# City of Albuquerque

RE: DRAINAGE PLAN FOR SECOND PRESBYTERIAN CHURCH ADDITION  
(J-14/D84) RECEIVED JUNE 1, 1989

GRADING AND DRAINAGE PLAN
ADDITION TO 2ND PRESBYTERIAN CHURCH
808 EDITH BLVD. N.E.

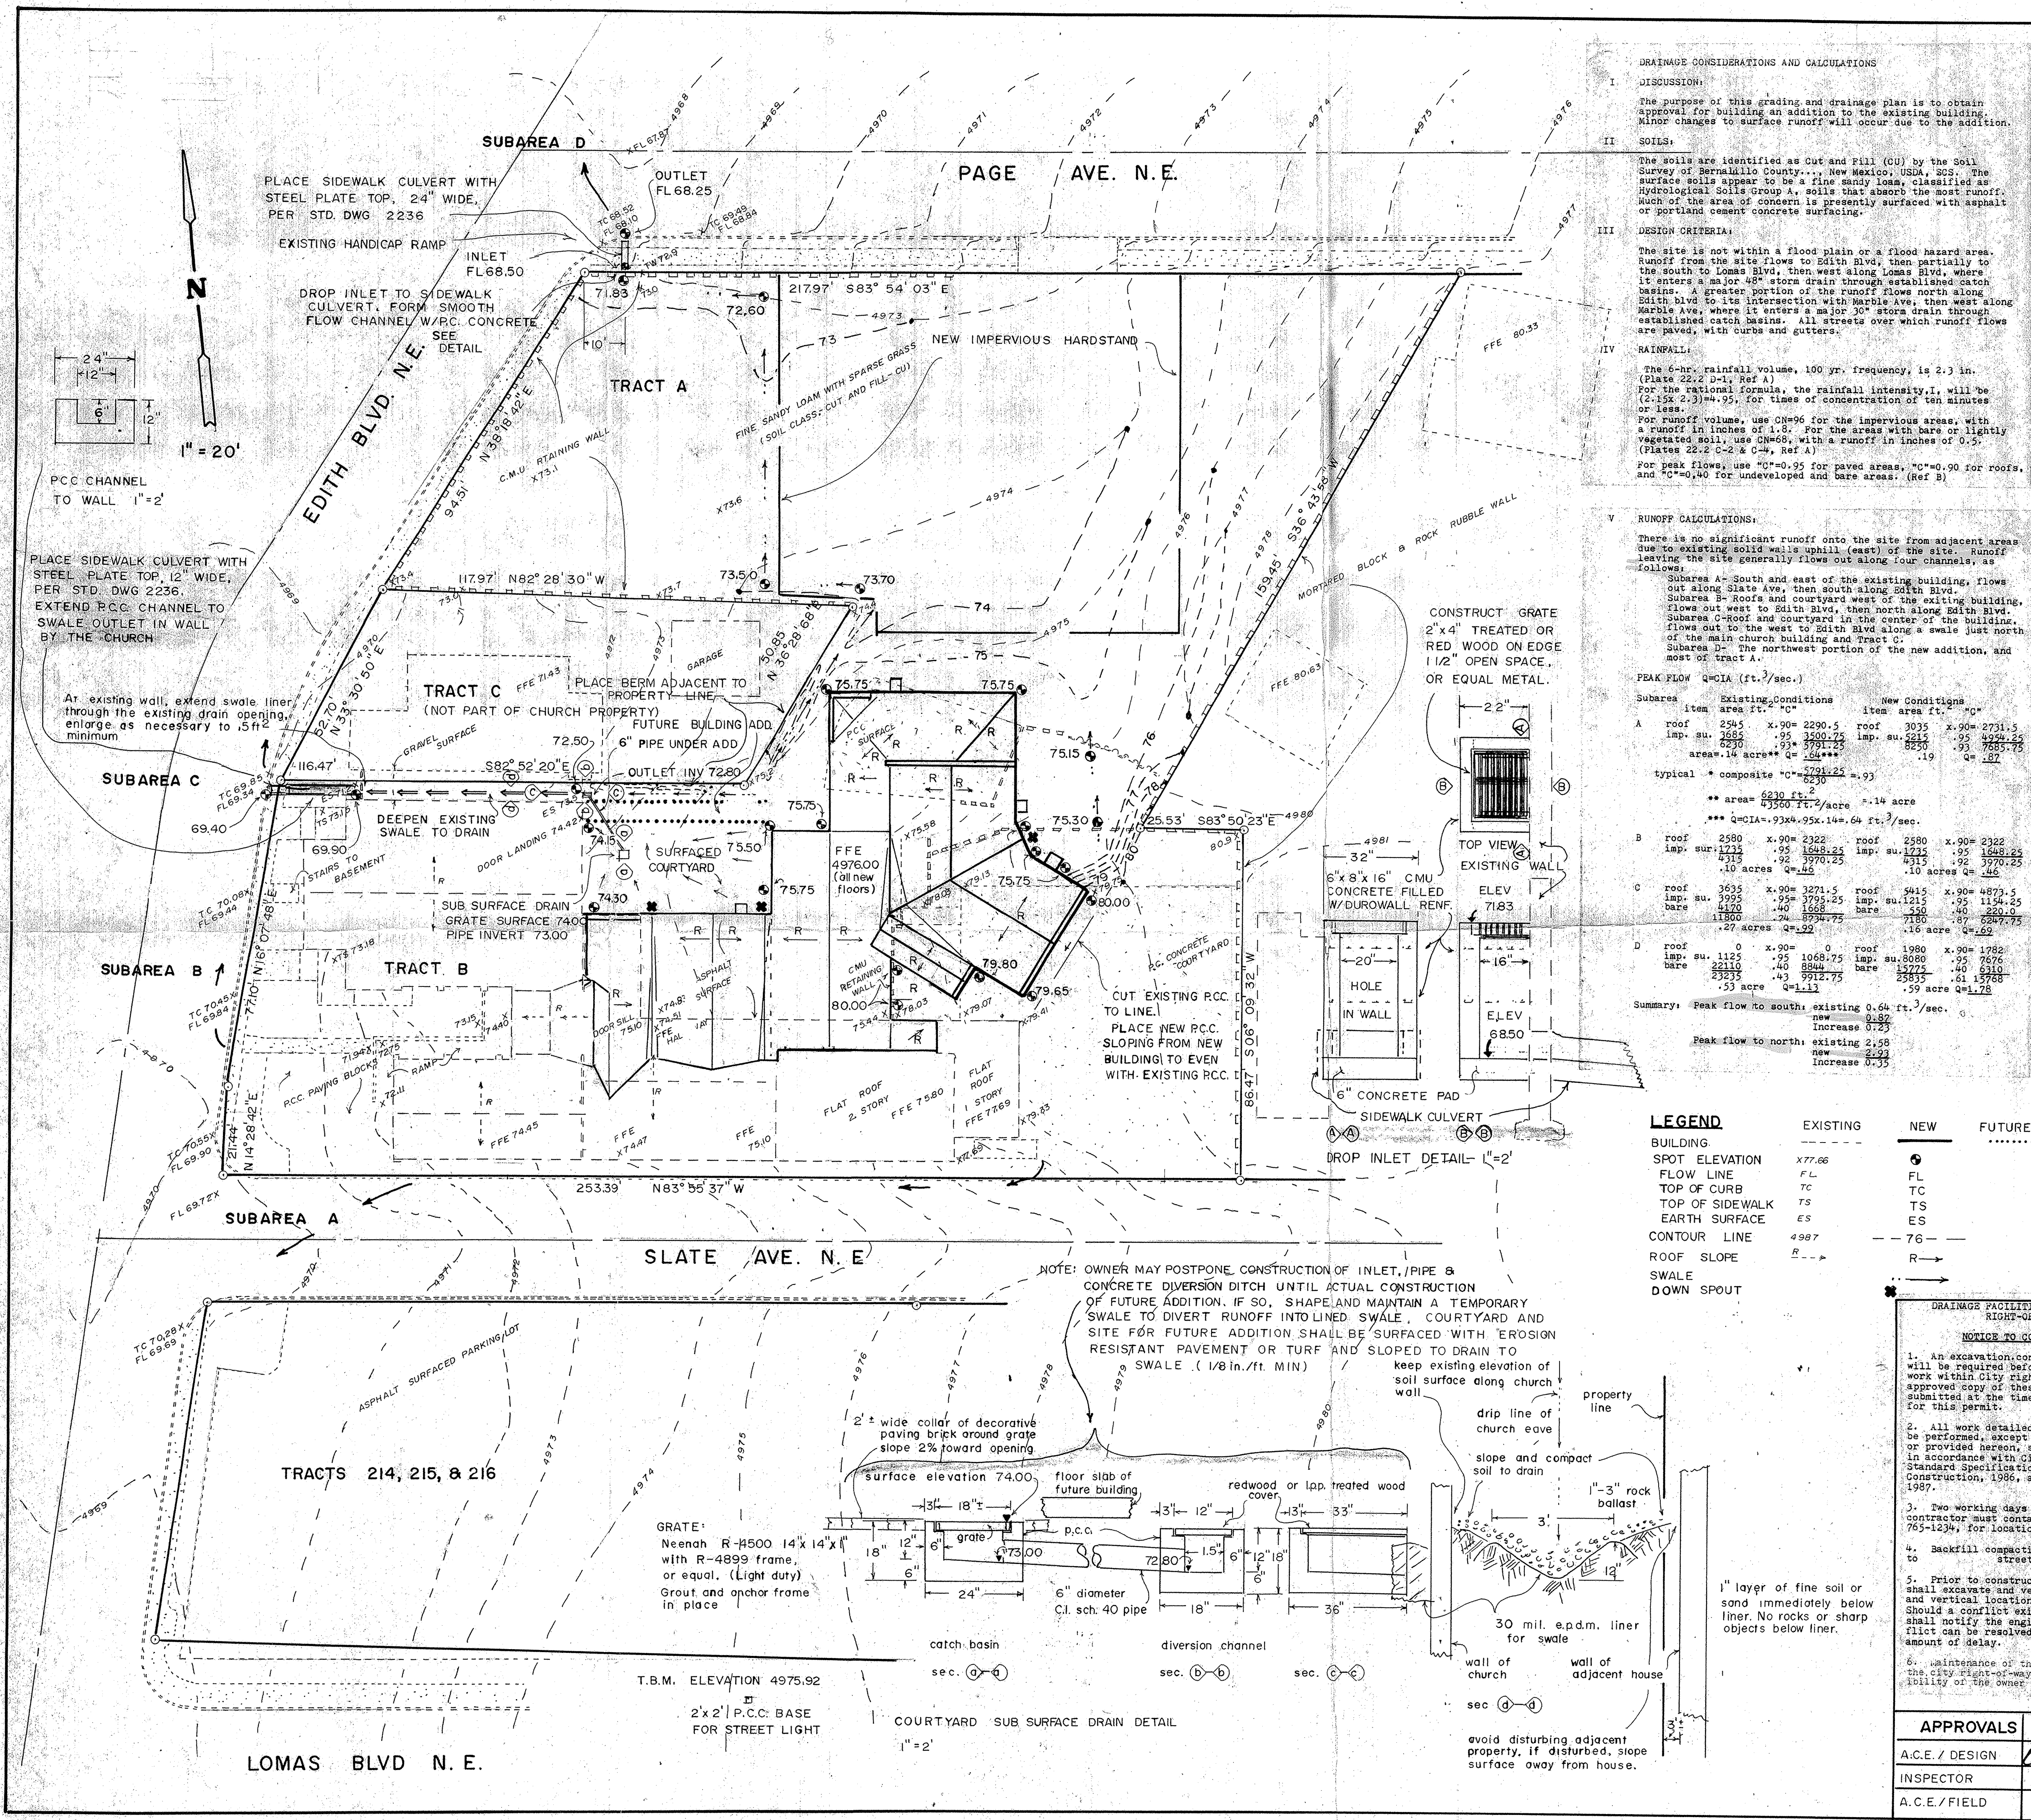
1. Are all the finish floor elevations at 4,976?
2. Please show a detail of the 18" notch at the sidewalk culvert at Page Avenue.
3. It may be more cost effective to place the subsurface drain when the future building addition is constructed. The 6" diameter pipe will be affected by the future additions foundation.
4. The liner between buildings used as a swale needs to be changed to a more permanent swale. The rock will be hard to walk on and the rock will puncture the liner if heavy objects are placed on it.
5. How will the flows be conveyed from the existing wall to Edith. The existing wall is at the termination of the liner swale.
